Item No. **Report of the Head of Planning, Transportation and Regeneration**

Address 51 KINGSEND RUISLIP

Development: Single storey outbuilding to rear for use as a sauna/games room

LBH Ref Nos: **3546/APP/2020/1034**

DRAWING TITLE
PROPOSED ELEVATIONS

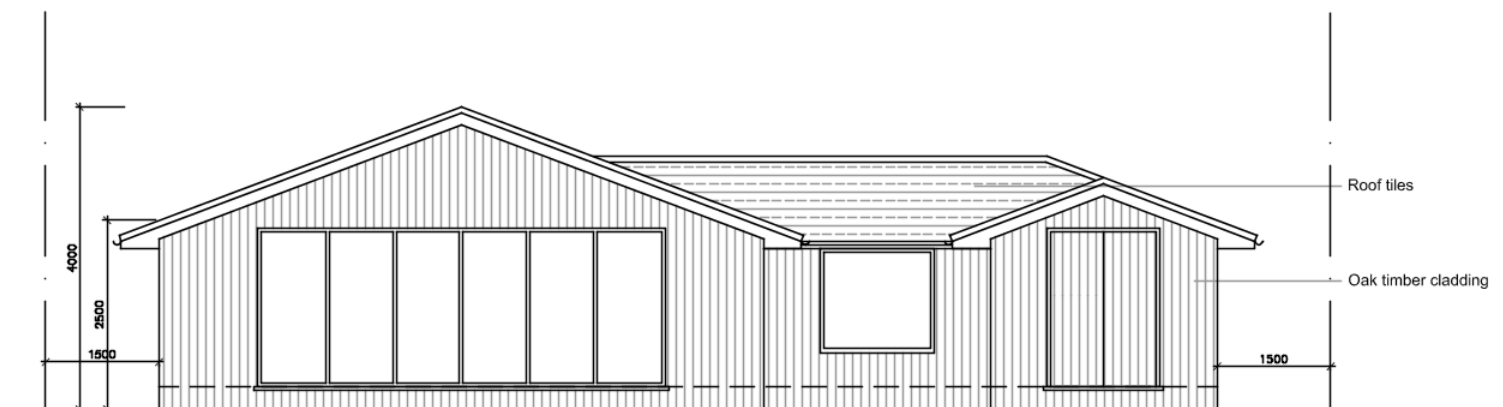
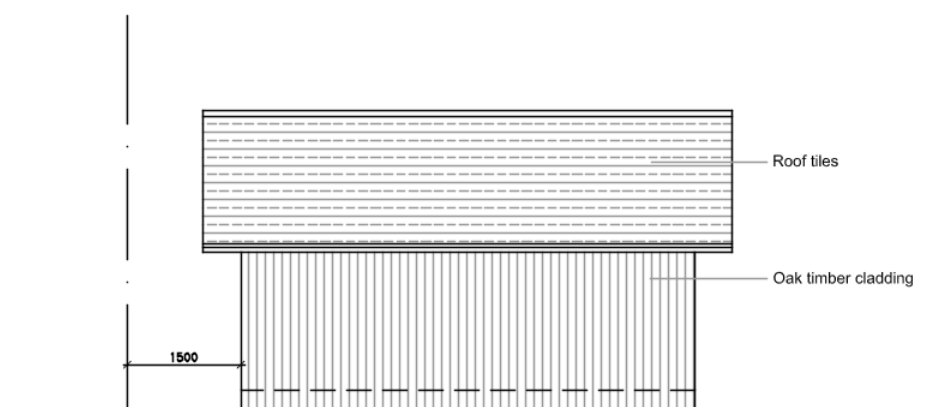
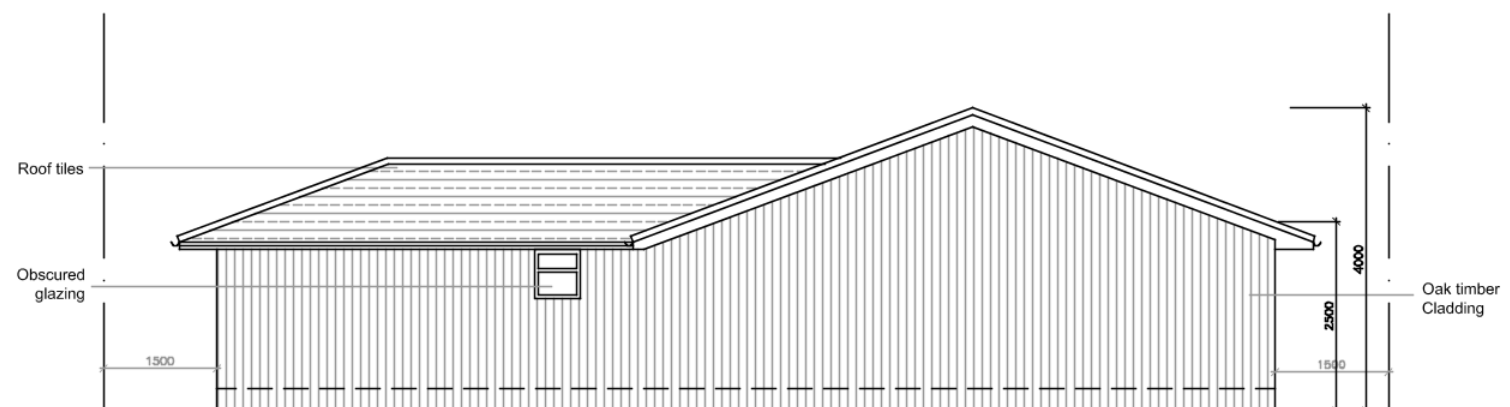
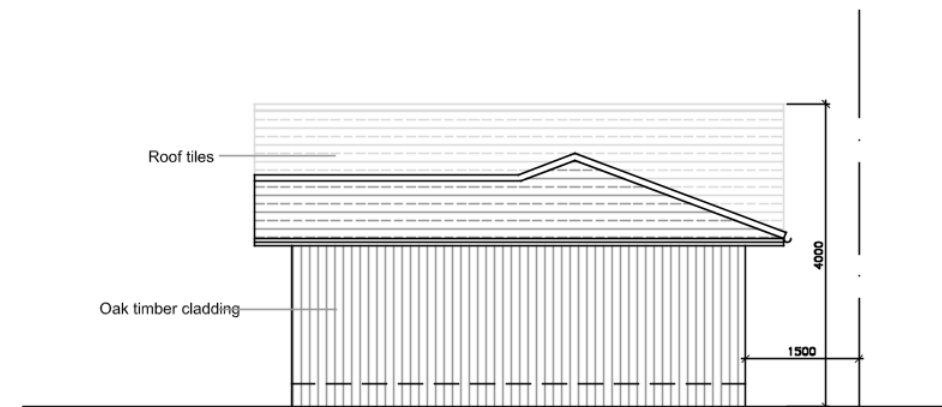
The proposed development would erect a substantial detached built form to the rear of the site. It would extend almost to the full width of the site. The building would be materially different to the main house, externally clad in timber characterised by a lodge-like appearance. The competing gable roof forms create a messy appearance to the elevation. As proposed it would not be considered a positive design statement. Outbuildings are not an established feature within the RVCA, and the proposed building would be a stark contrast to the existing building on the site.

It would be significantly harmful to the character and appearance of the site. The outbuilding would result in some harm to the conservation area and in this instance it would be defined as less than substantial. There are concerns it would set an unwelcome precedent for similar structures to be erected within neighbouring sites. It would need to be duly noted that conservation areas are not designated as a series of street scenes. The proposed outbuilding would be visible from within the rear garden of the application site and neighbouring gardens. These form part of the environment in which the heritage asset is experienced and just because there are not public views does not lessen the requirement to pay special attention to the desirability of preserving or enhancing the conservation area.

Therefore in terms of appearance, it is considered that the building would not respect the character of the existing property and would be contrary to the character and appearance of the area and the Ruislip Village Conservation Area. Thus, the proposed outbuilding, by virtue of its size, scale, bulk and height, would fail to harmonise with the architectural composition of the original dwelling and would be detrimental to the character, appearance and visual amenities of the wider Ruislip Village Conservation Area and would fail to either preserve or enhance the character or appearance of the surrounding Ruislip Village Conservation Area. The proposal is therefore contrary to Policies BE1 and HE1 of the Hillingdon Local Plan: Part One - Strategic Policies (November 2012), Policies DMHB 1, DMHB 4, DMHB 11 and DMHD 2 of the Hillingdon Local Plan: Part Two - Development Management Policies (January 2020), Policy 7.8 of the London Plan (2016) and the NPPF.

The proposed outbuilding, by virtue of its size, scale, bulk and height, would fail to harmonise with the architectural composition of the original dwelling and would be detrimental to the character, appearance and visual amenities of the wider Ruislip Village Conservation Area and would fail to either preserve or enhance the character or appearance of the surrounding Ruislip Village Conservation Area. The proposal is therefore contrary to Policies BE1 and HE1 of the Hillingdon Local Plan: Part One - Strategic Policies (November 2012), Policies DMHB 1, DMHB 4, DMHB 11 and DMHD 2 of the Hillingdon Local Plan: Part Two - Development Management Policies (January 2020), Policy 7.8 of the London Plan (2016) and the NPPF.

DHIVa <i>designs</i> www.dhivadesigns.co.uk	
SITE ADDRESS	
51 KINGSEND RUISLIP HA4 7DD	
DRAWING TITLE	PROPOSED PLANS
DATE	MARCH 2020
SCALE	1:100 @ A3
DRAWING NO.	DD230-04-P1
REVISION	NP

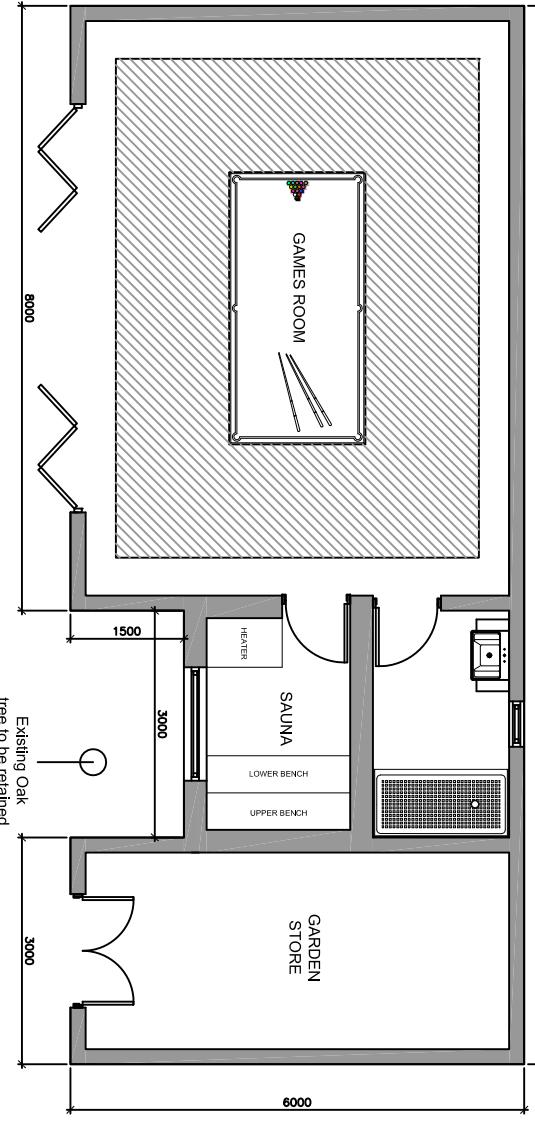
The outbuilding would be extremely large in scale and internally it would be subdivided into several rooms. The applicant states that they would be used as a games room, sauna, shower room and garden storage area. It would be situated at the end of the rear garden, set in a minimum of 1.5m from the side and rear boundaries. It measures 14 m in width by 6 m in depth set under a dual pitched roof with two gable ends, an eaves height to 2.5 m and a maximum height of 4 m. The building will have a tiled roof and a timber cladding exterior which fails to match the host dwelling, bifolding doors, a large window and patio doors in the north facing front elevation and a small window in the south facing rear elevation. The building will provided in excess of 80 sqm of floor space which exceeds the guidance of 30 sqm. Although it is noted that this a very spacious plot, the resulting floor space of 80 sqm would still be 65.84% of the footprint of the host dwelling at 121.5 sqm

The site is covered by a TPO and there are trees and vegetation positioned very close to the building. However no information relating to this has been provided. Thus, in the absence of a Tree Survey and Arboricultural Implication Assessment the proposal has failed to demonstrate that the development will safeguard existing protected trees on and adjoining the site and further fails to demonstrate protection for and long-term retention of those trees. The proposal is therefore detrimental to the visual amenity of the street scene and the Ruislip Village Conservation Area contrary to Policies BE1 and HE1 of the Hillingdon Local Plan: Part One - Strategic Policies (November 2012) and Policies DMHB 1, DMHB 4, DMHB 11, DMHB 14 and DMHD 2 of the Hillingdon Local Plan: Part Two - Development Management Policies (January 2020).

In the absence of a Tree Survey and Arboricultural Implication Assessment the proposal has failed to demonstrate that the development will safeguard existing protected trees on and adjoining the site and further fails to demonstrate protection for and long-term retention of those trees. The proposal is therefore detrimental to the visual amenity of the street scene and the Ruislip Village Conservation Area contrary to Policies BE1 and HE1 of the Hillingdon Local Plan: Part One - Strategic Policies (November 2012) and Policies DMHB 1, DMHB 4, DMHB 11, DMHB 14 and DMHD 2 of the Hillingdon Local Plan: Part Two - Development Management Policies (January 2020).
